CITY OF ALBUQUERQUE

October 24, 2017

RE: 4605 Albany NE
Grading Plan
Stamp Date: 10/17/17
Hydrology File: B12D014

ENGINEER'S SEAL  9/27/17 DAVID SOULE P.E. #14522	4605 ALBANY COURT N.W.	DRAWN BY WCWJ
		DATE 9-26-17
	GRADING AND DRAINAGE PLAN  1606 CENTRAL AVENUE SE SUITE 201 ALBUQUERQUE, NM 87106 (505) 872-0999	21803-LAYOUT-9-26-17
		SHEET # — JOB # 21803

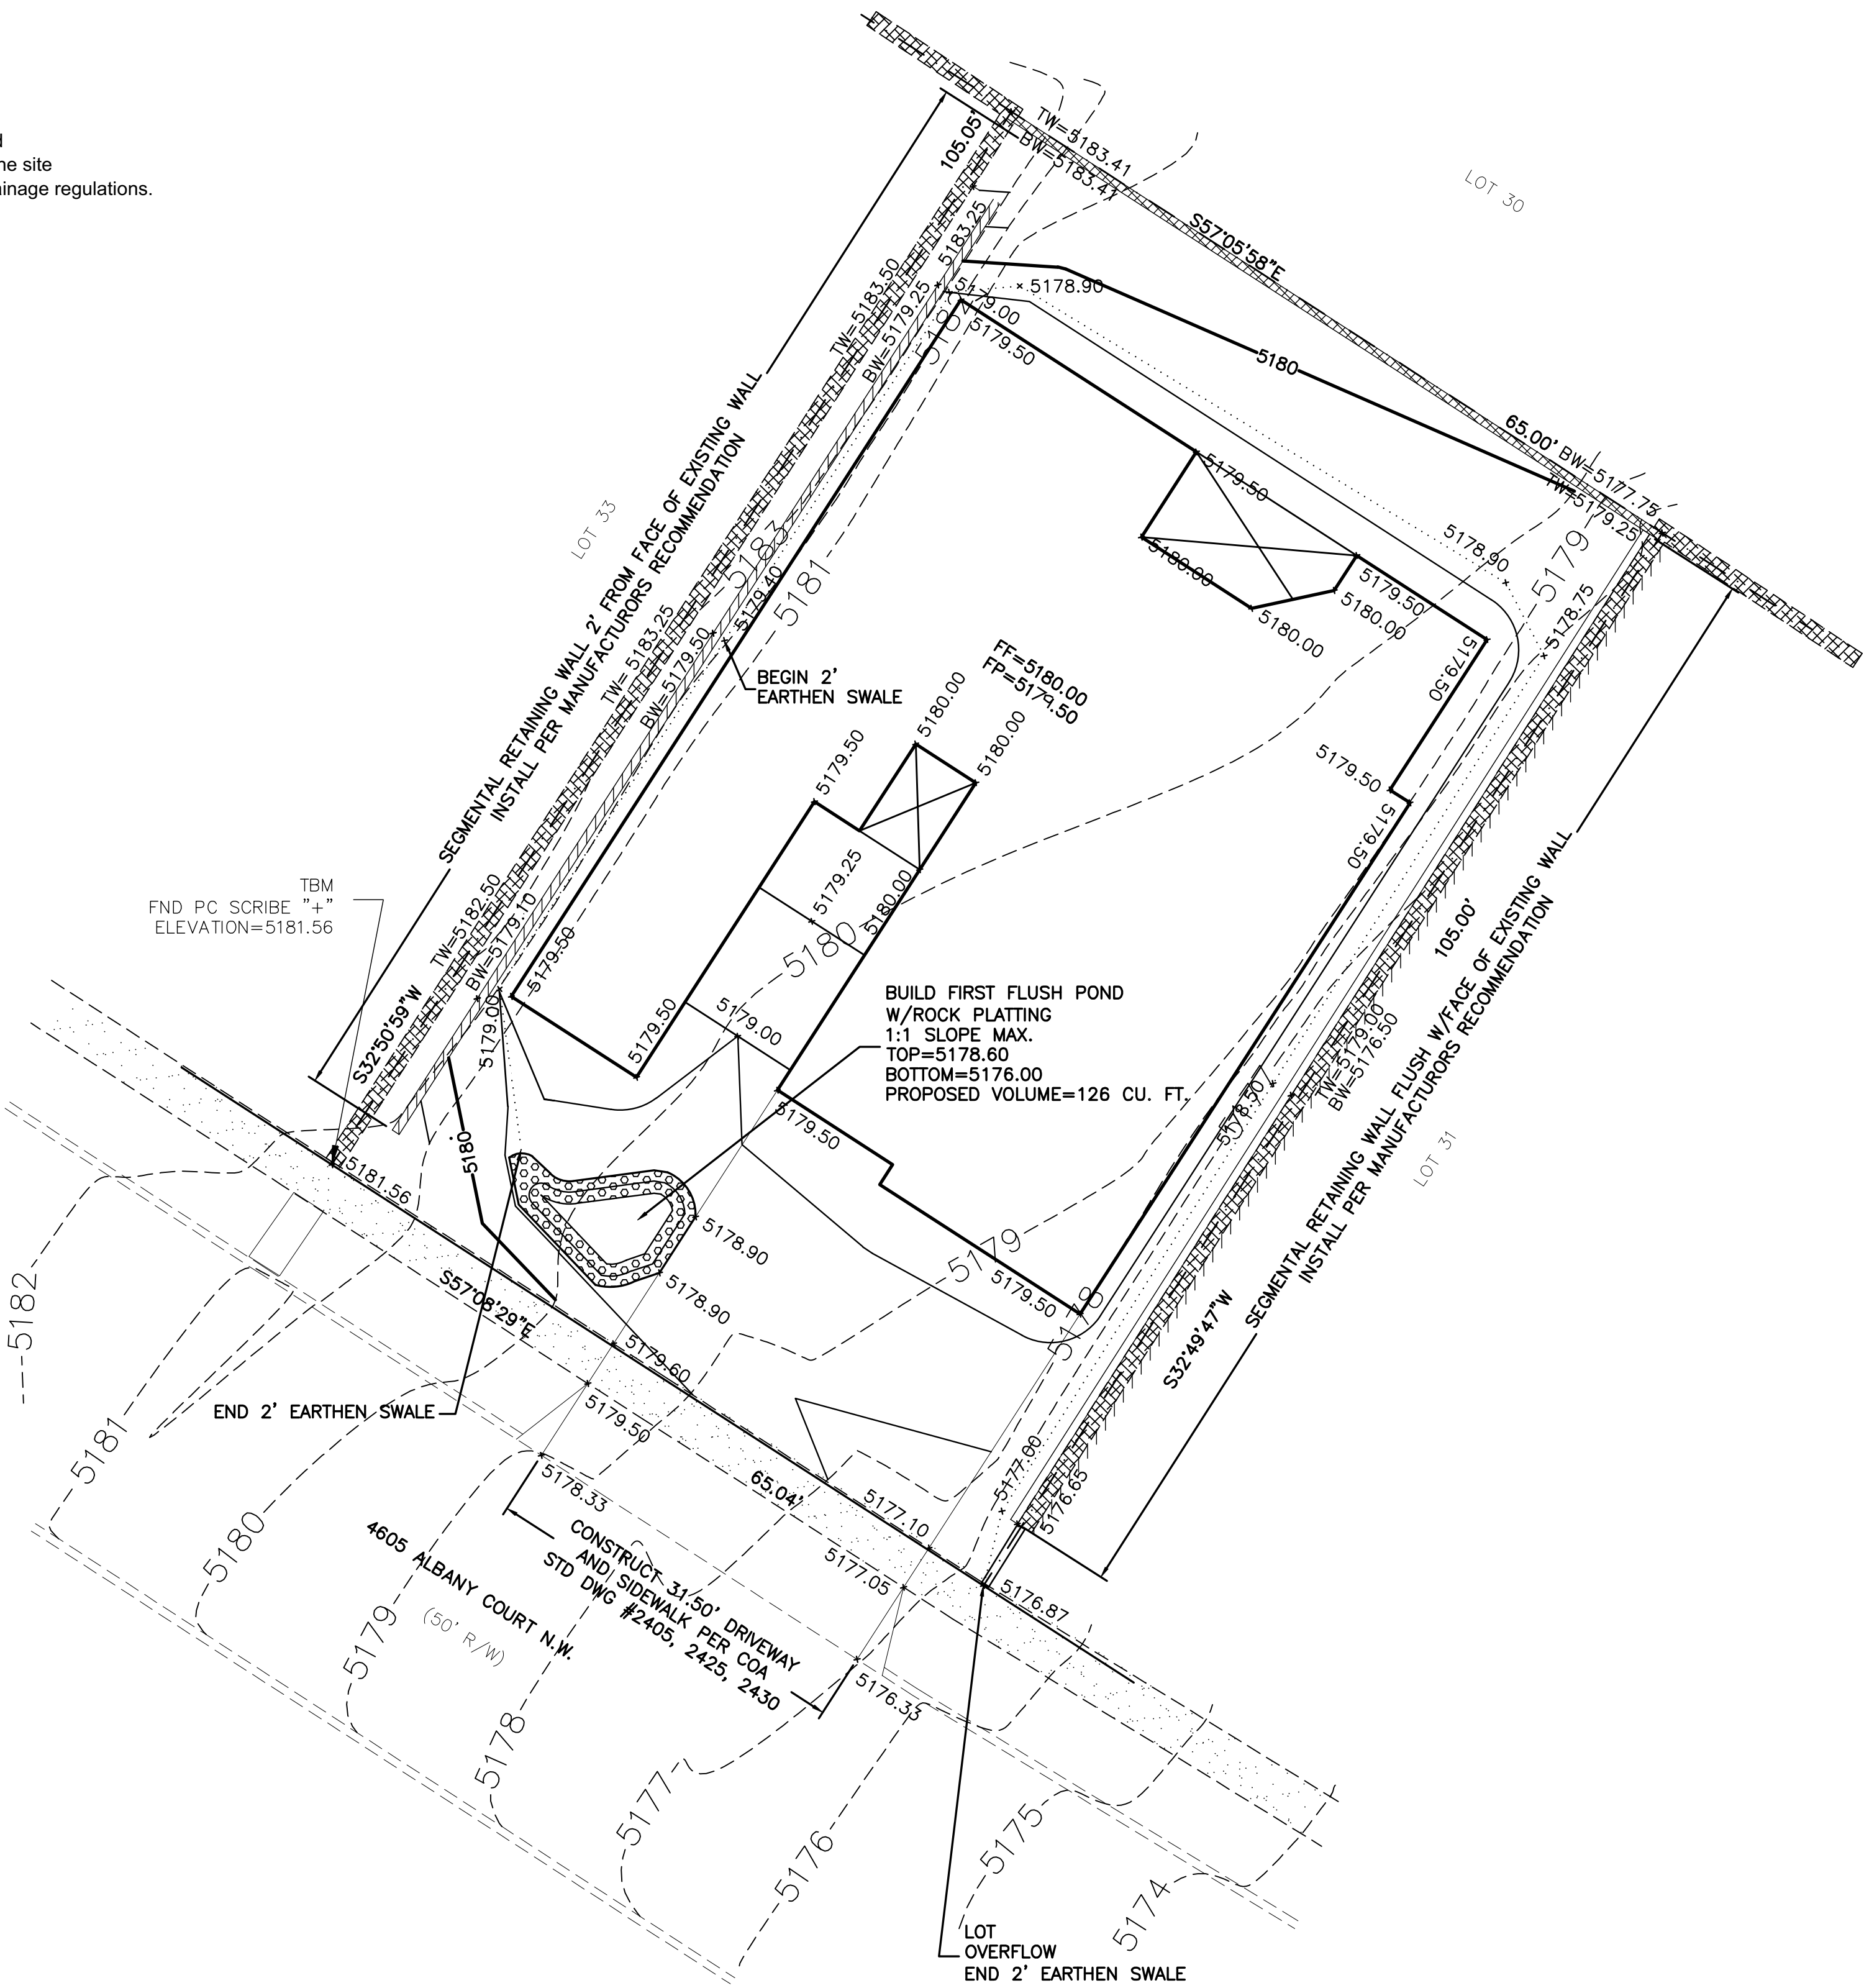
1. Please provide a cross section for both proposed retaining walls. Please include the existing retaining wall, the property line, and footer information. I'm epically concerned about the East wall since you are putting this flush with the existing wall. I want to ensure the integrity of the existing retaining walls. See Attached sheet for the location of the cross sections in question.
